Land Use Planning
Yorkshire Water Services Ltd
Midway
Western Way
Halifax Road
Bradford
BD6 2LZ

Your Ref: 2014/60/92535/W
Our Ref: Q014133

Shop Lane, Kirkheaton, Huddersfield - Outline application for erection of 49 dwellings, formation of access and associated infrastructure

PROPOSED PLANNING LAYOUT

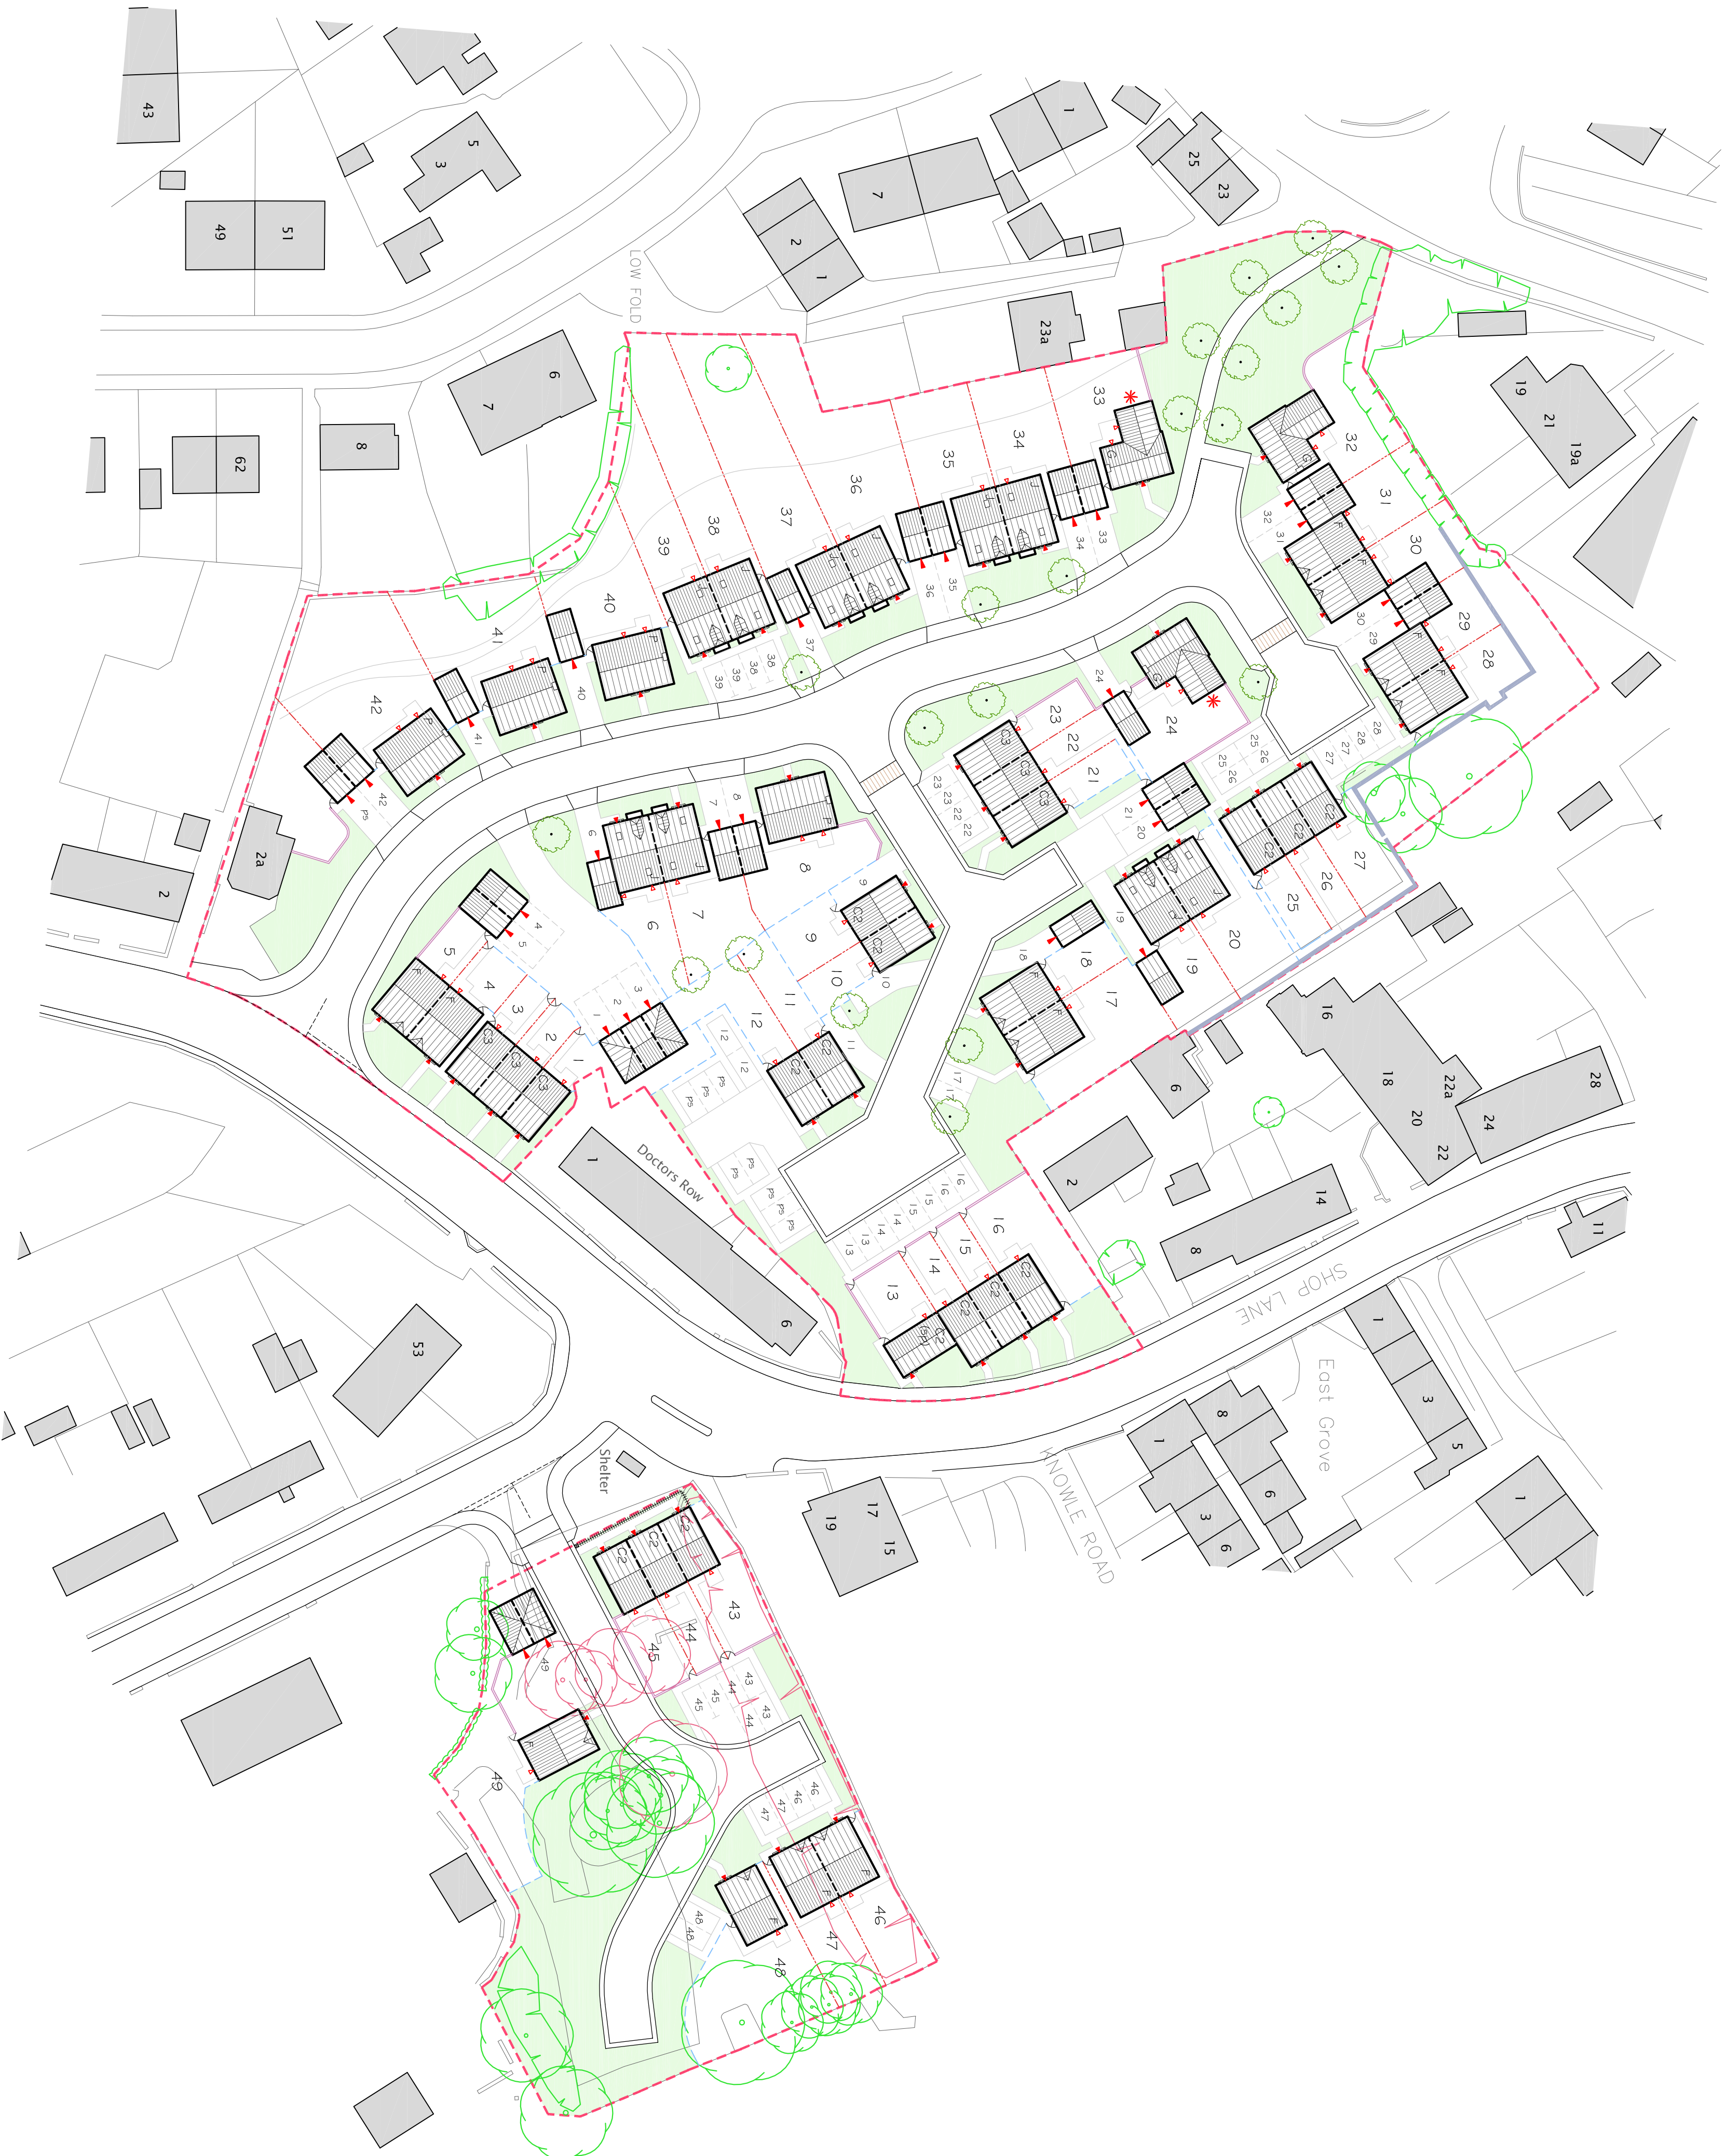
EXISTING INFRASTRUCTURE - On the Statutory Sewer Map, there is a 300 mm diameter abandoned public sewer recorded to cross the larger site and a private trade effluent point at the southern boundary of the site. Confirmation required to prove the 300 mm abandoned sewer has either been removed or grubbed out.

On the Statutory Sewer Map, there is a public combined sewer recorded to cross the smaller site to the East of Shop Lane. In this instance, YWS would look for this matter to be controlled by Requirement H4 of the Building Regulations 2000. It is essential that all infrastructure is taken into account in the design of the scheme.

Foul water domestic waste should discharge to the 525 mm diameter public foul sewer recorded in Shop Lane, at a point adjacent from the site.
